SITE/SOIL EVALUATION FOR ON-SITE WASTE WATER

APPLICANT: Pine Grove Dev. Corp PHONE: _____ APPLICATION DATE: 8-5-90
 ADDRESS: _____
 COUNTY: HARNETT PROPERTY SIZE: .50 Ac. PROPOSED FACILITY: DW
 LOCATION OF SITE: Lot 48 Overview Ests.
 WATER SUPPLY: On-Site Well _____ Community _____ Public Other _____ EVALUATION BY: Auger Boring Pit _____ Cut _____

.. SURVEY FOR ..

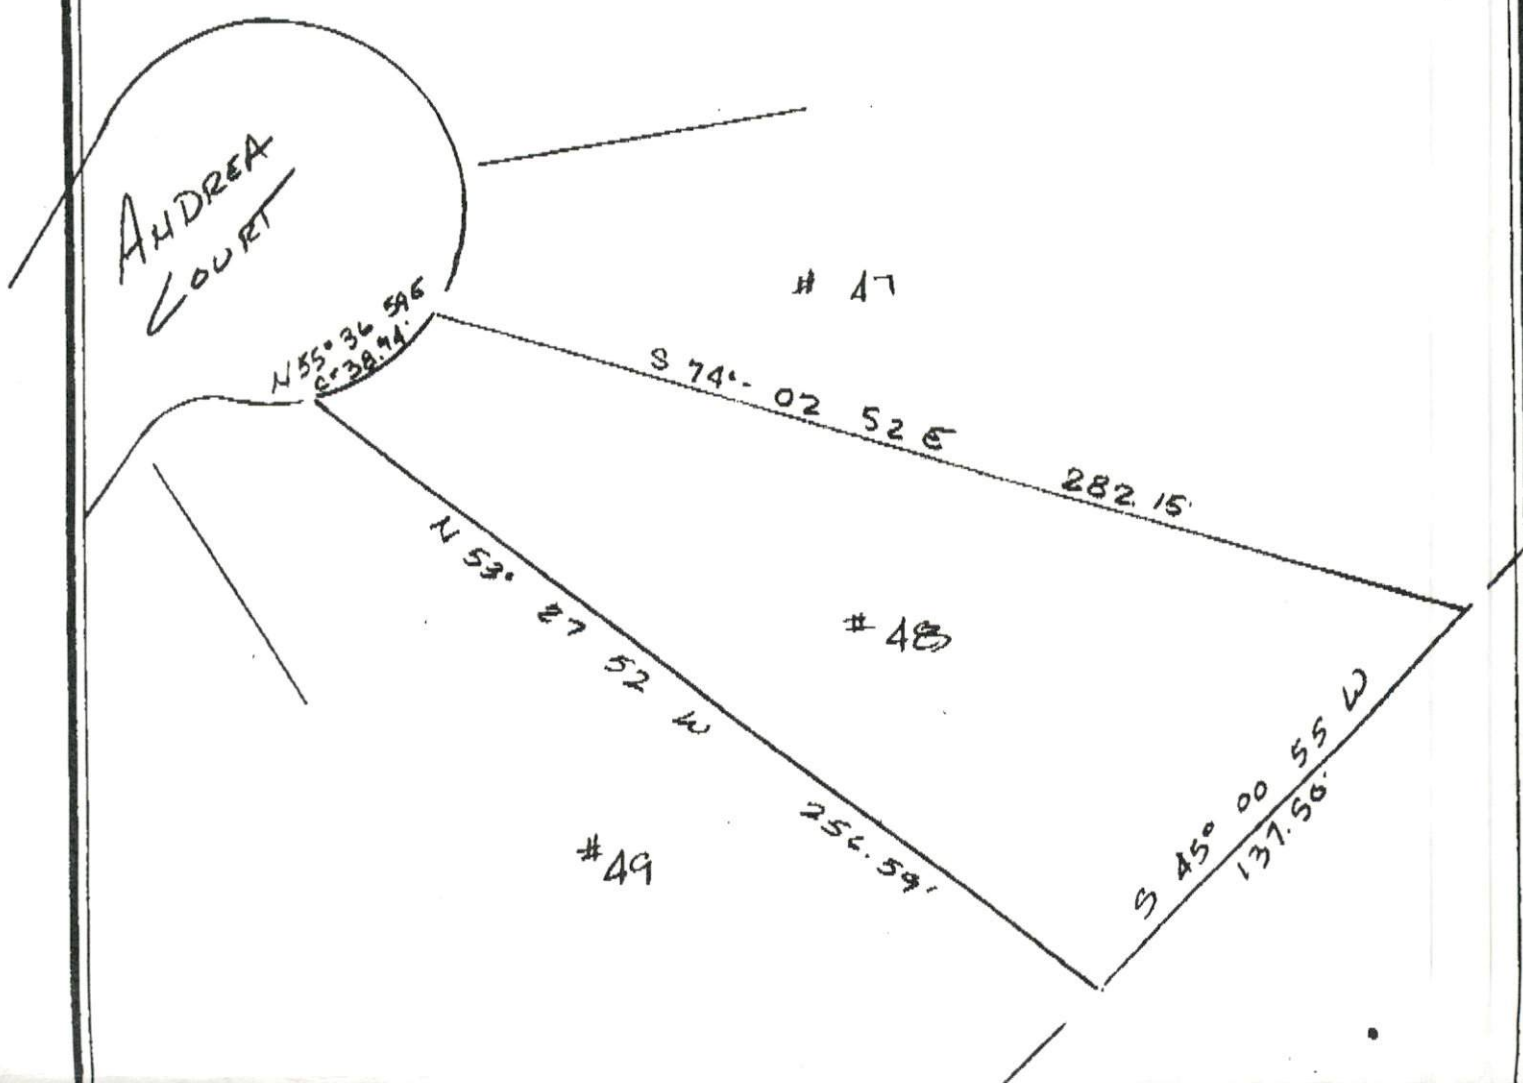
COMMENTS:
Plot plan does not show home location and house corners are not marked.
